Alterations and Additions to St Philip's Christian College Cessnock.  
Application number: SSD- 10360337

I am writing in response to a letter received last week regarding the proposed development of the St Philip Christian College at 10 Lomas Lane Nulkaba. I have been working with our neighbours at 305 - 311 Wine Country Drive Nulkaba and wish to add my comments to the proposed alterations to Wine Country Drive and to the access to our properties that will arise from the planned development.

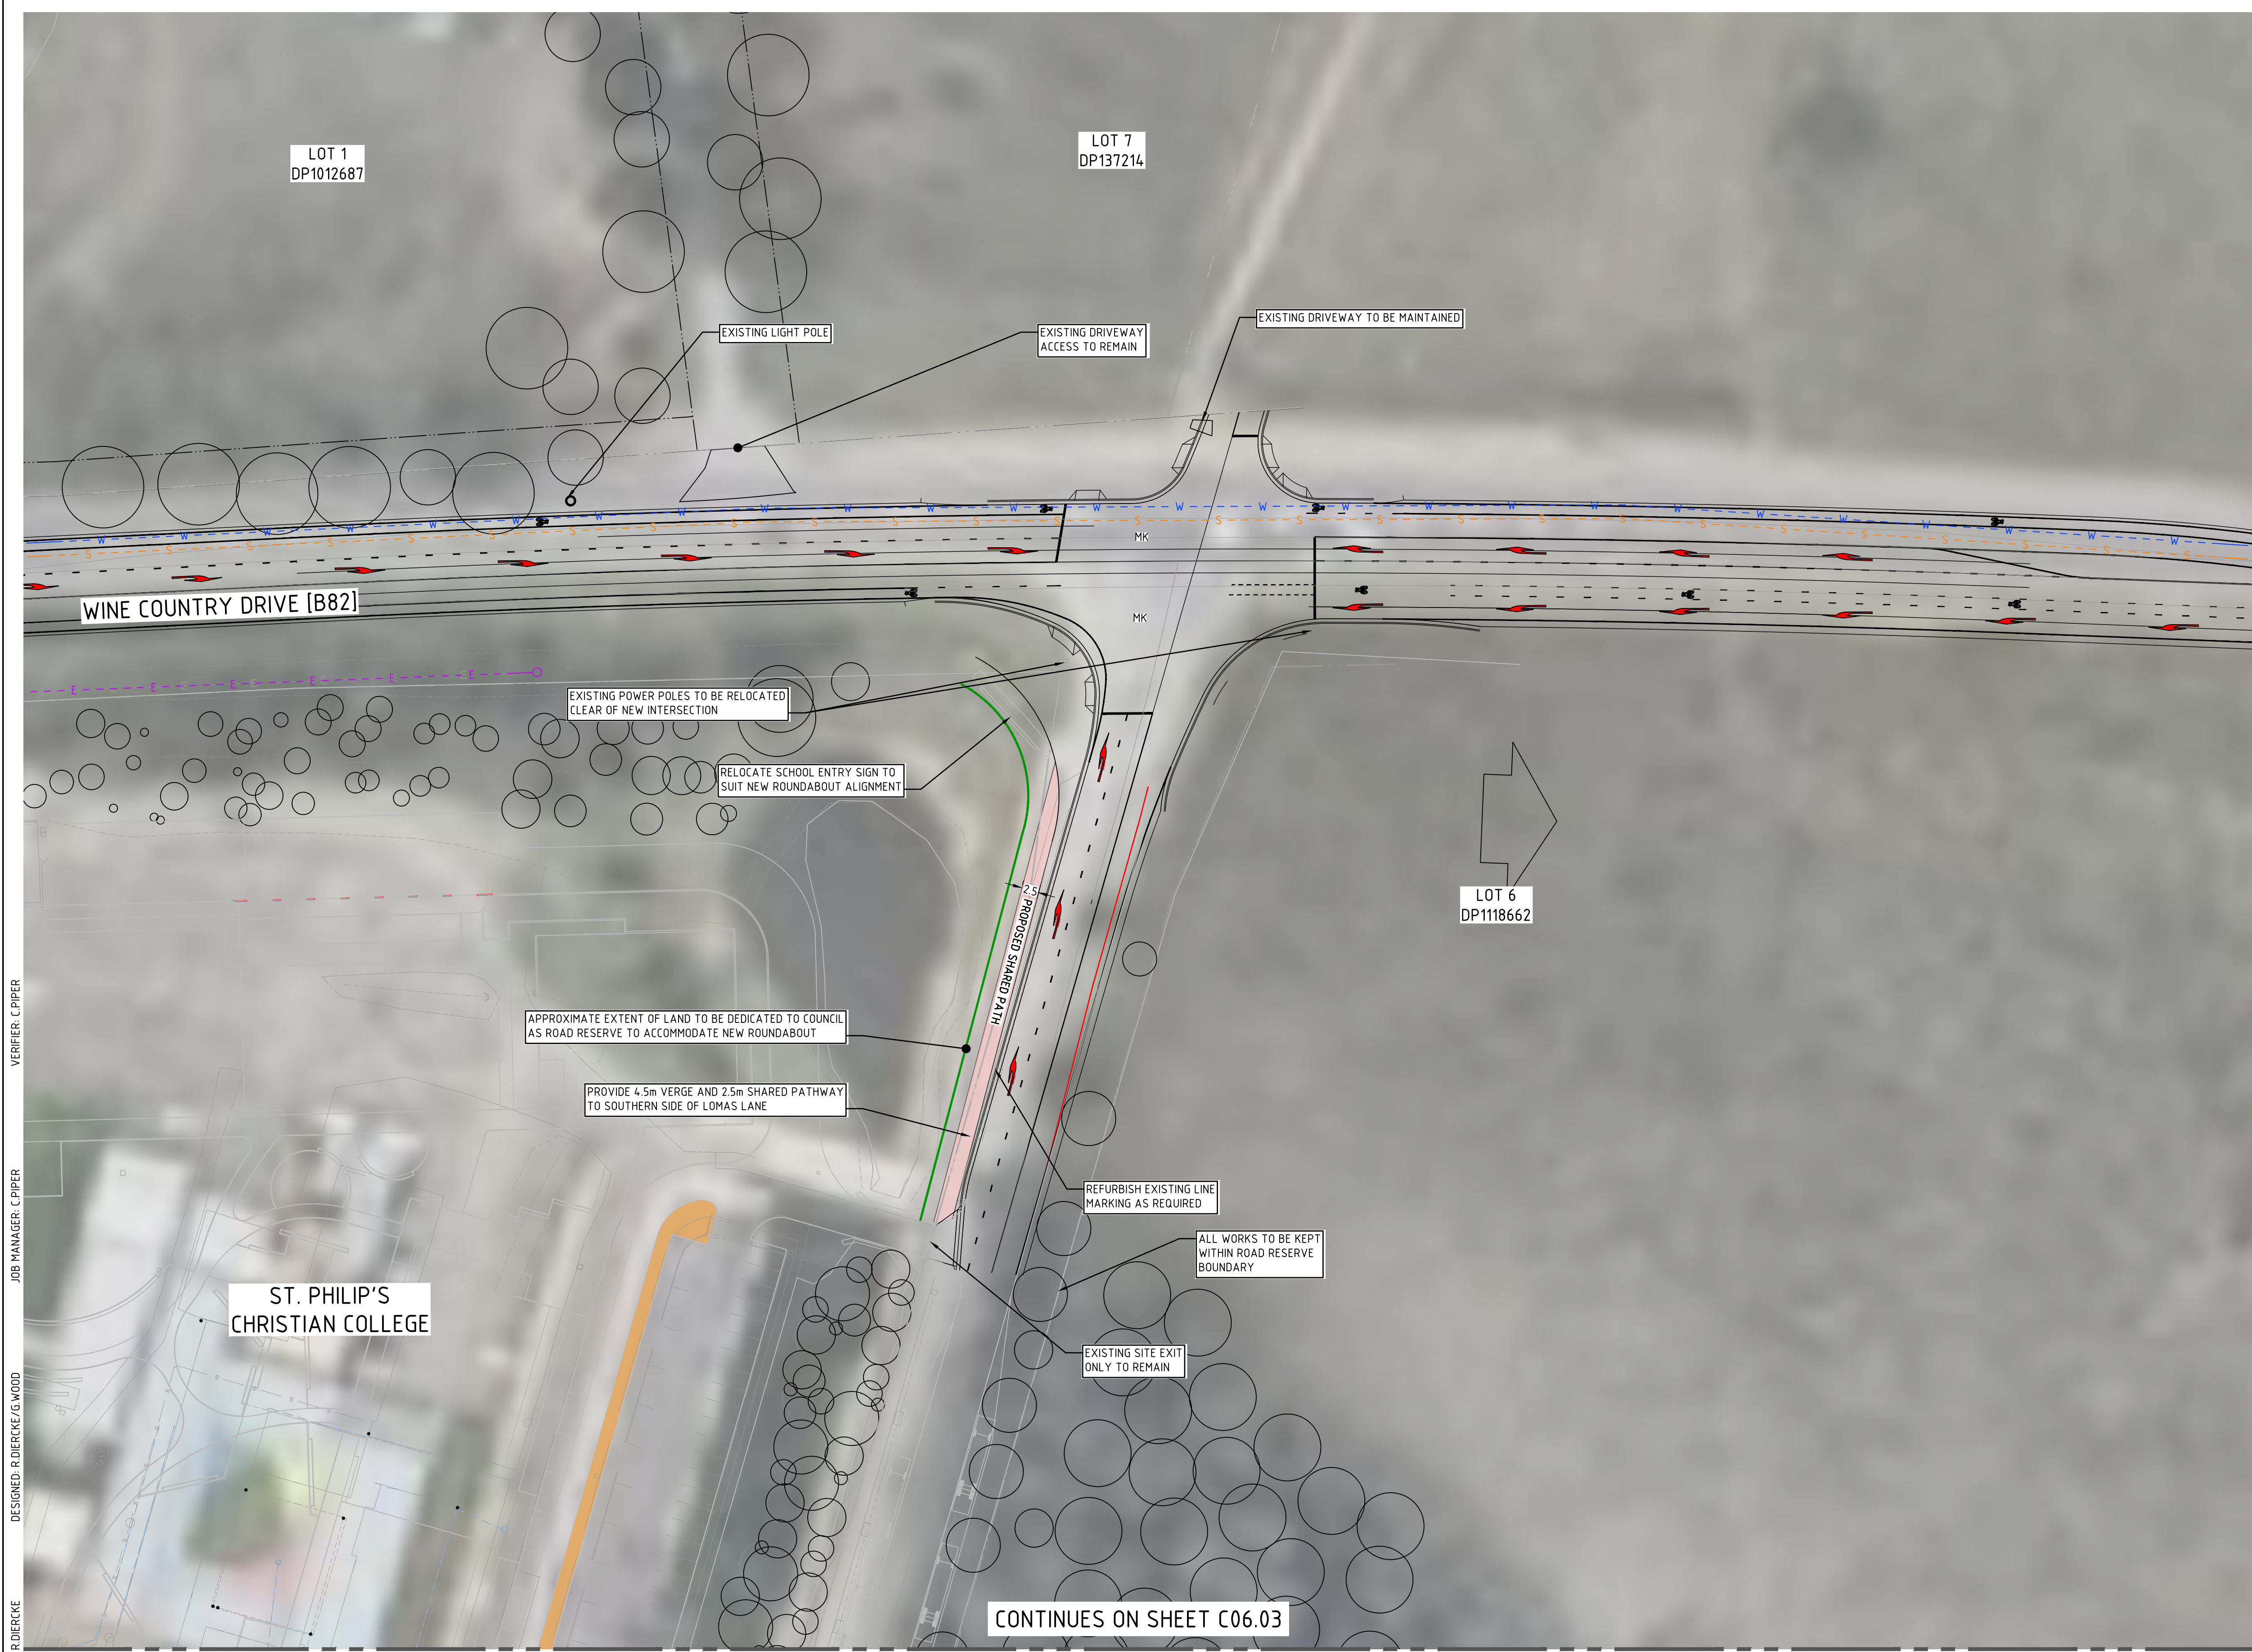
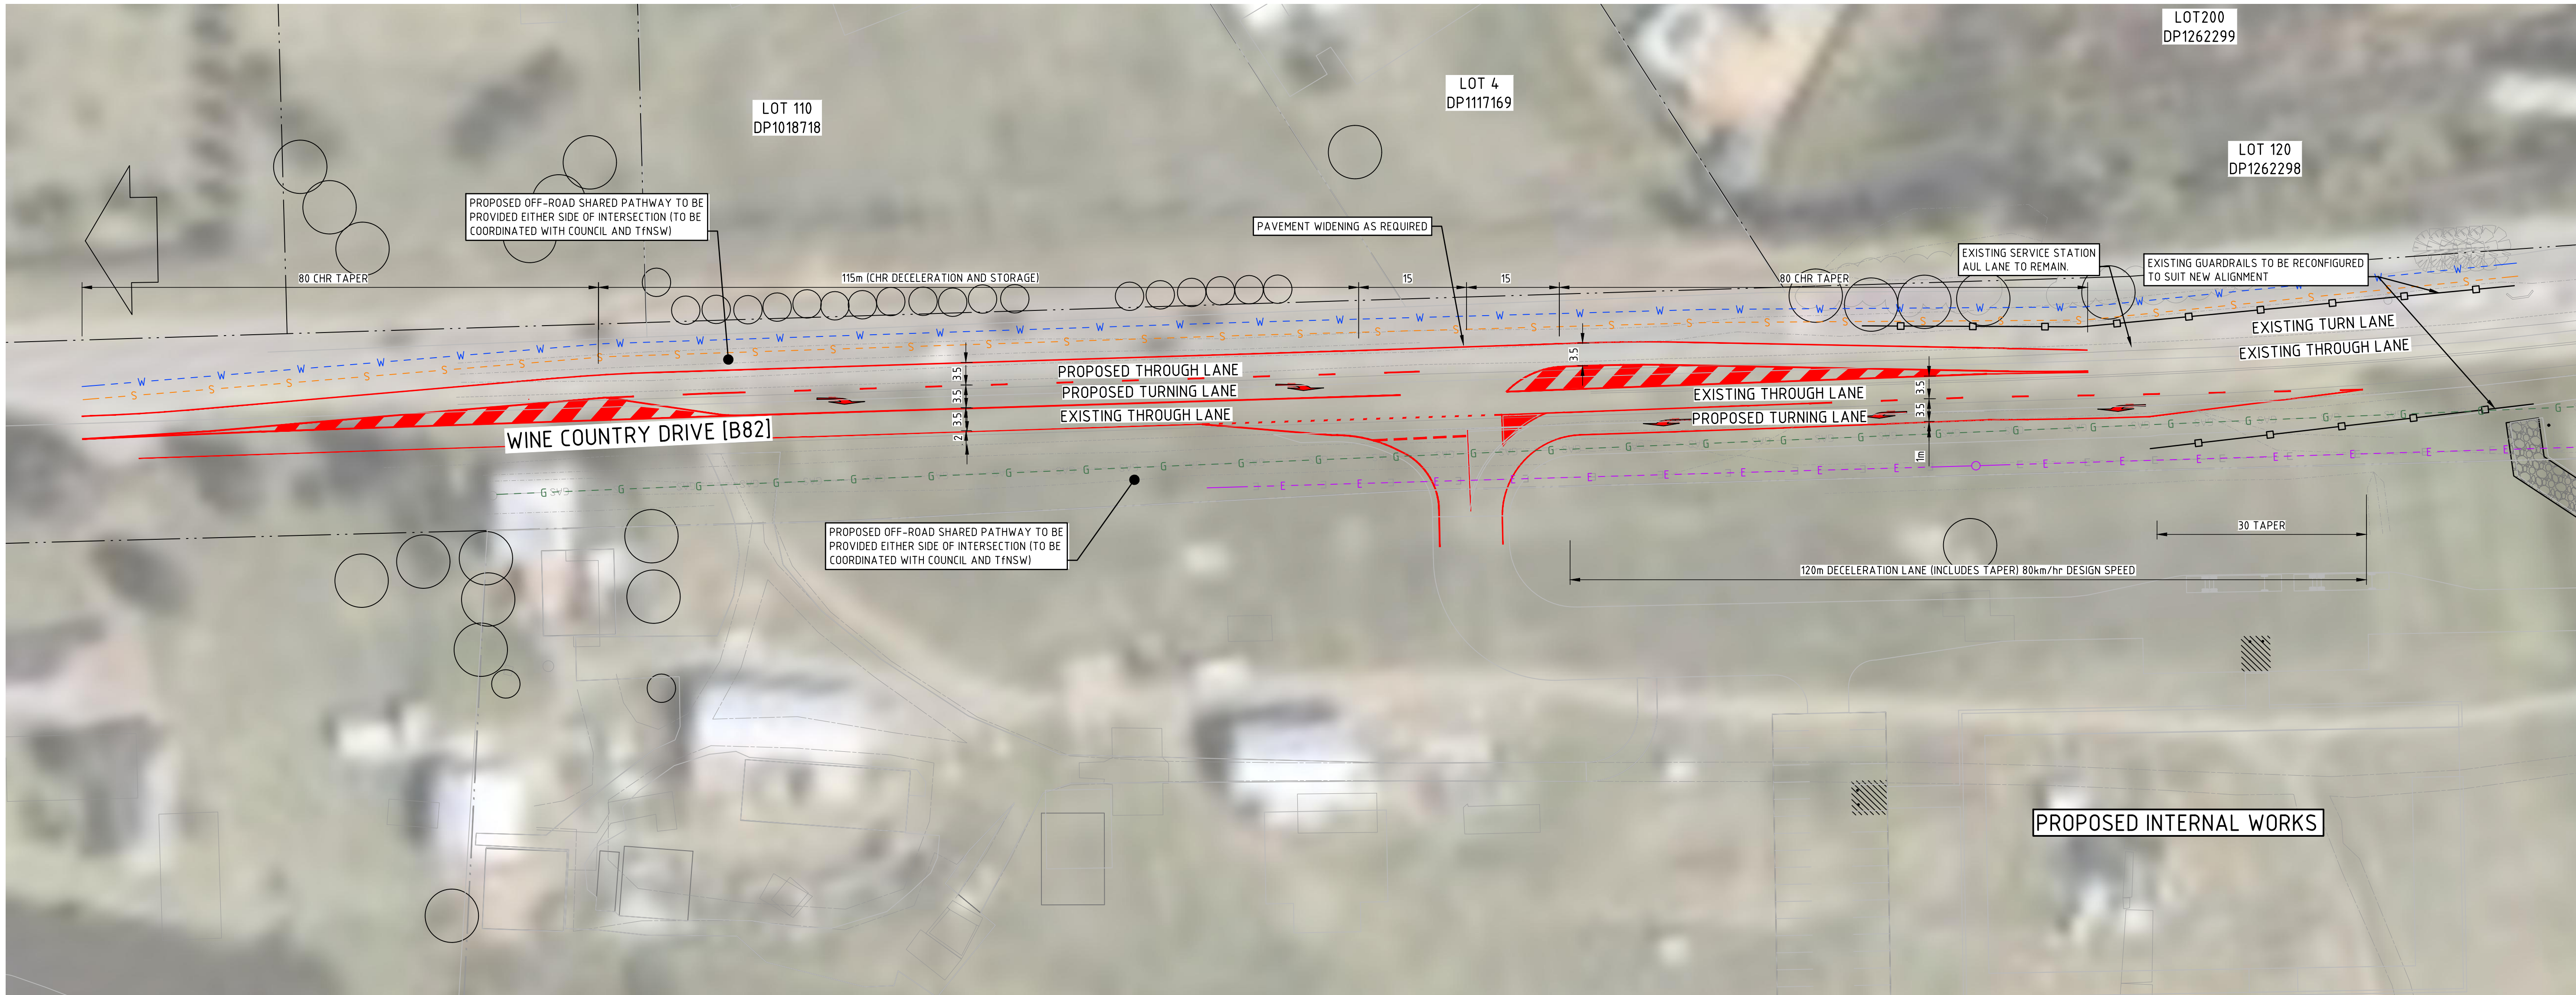
The Signalled option needs to include a righthand turn for south bound traffic as tractors, working vehicles and visitors to the properties require ready access. It is unclear from the proposal and attached

diagrams that a righthand turn lane for southbound traffic will be provided. Safety is an important issue especially as planned traffic loads increase. Appropriate passing lanes for traffic to allow vehicles and tractors turning right off WCD into properties at 305 - 311 WCD will be an essential requirement.
